Application for Planning Permission

Development: 1 No 4 bed chalet bungalow. This application is in CIL Zone 4 and is CIL Liable as a new dwelling.
Location: Dawn Cottage 44 Pagham Road Pagham PO21 4NP

Proposed West Elevation 44

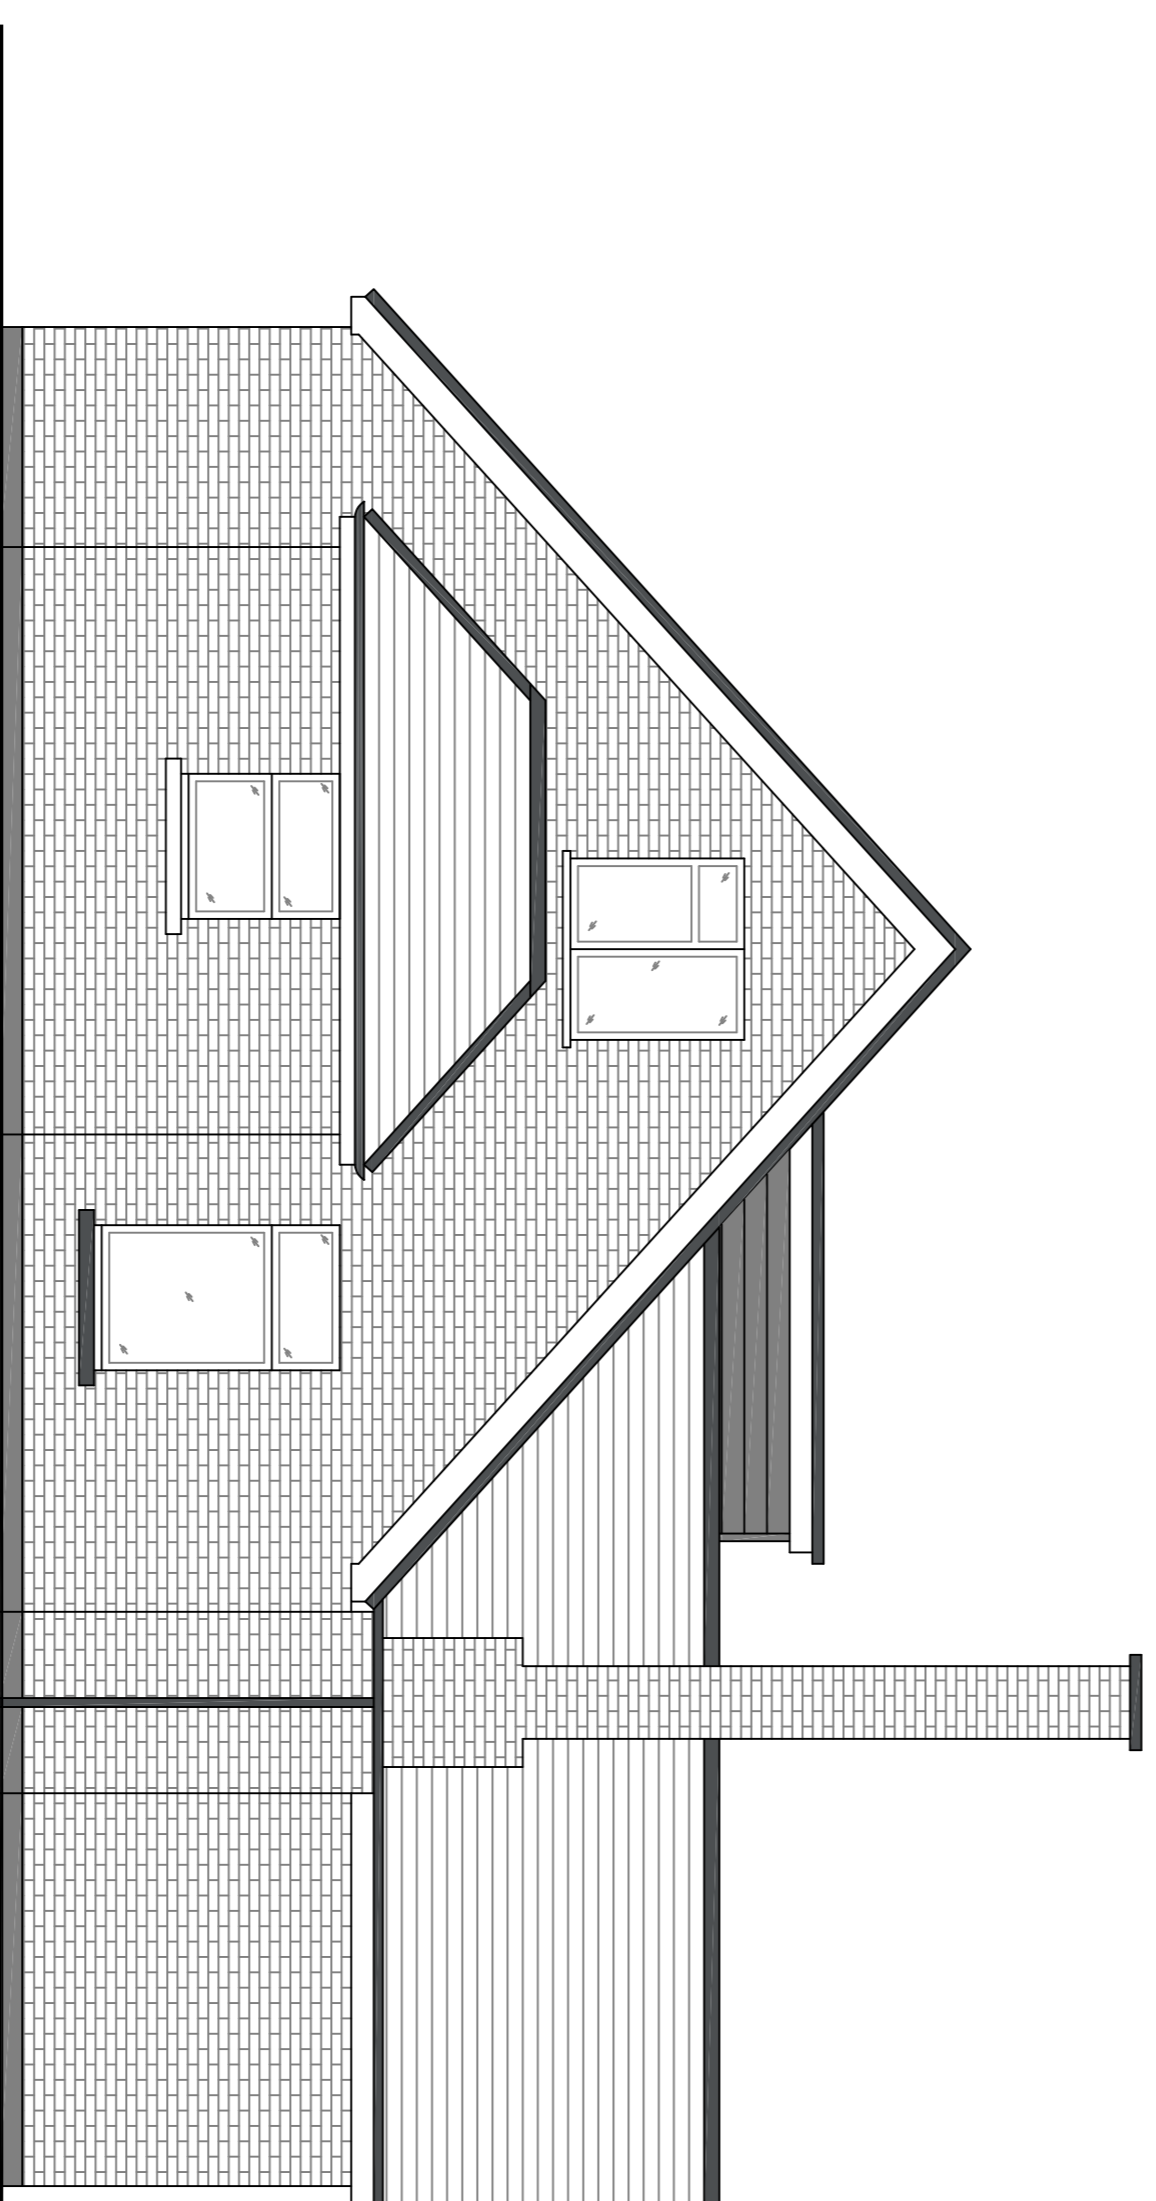
Please confirm why you have supplied two existing and proposed north and south elevations and east and west elevations as the elevations are the same.
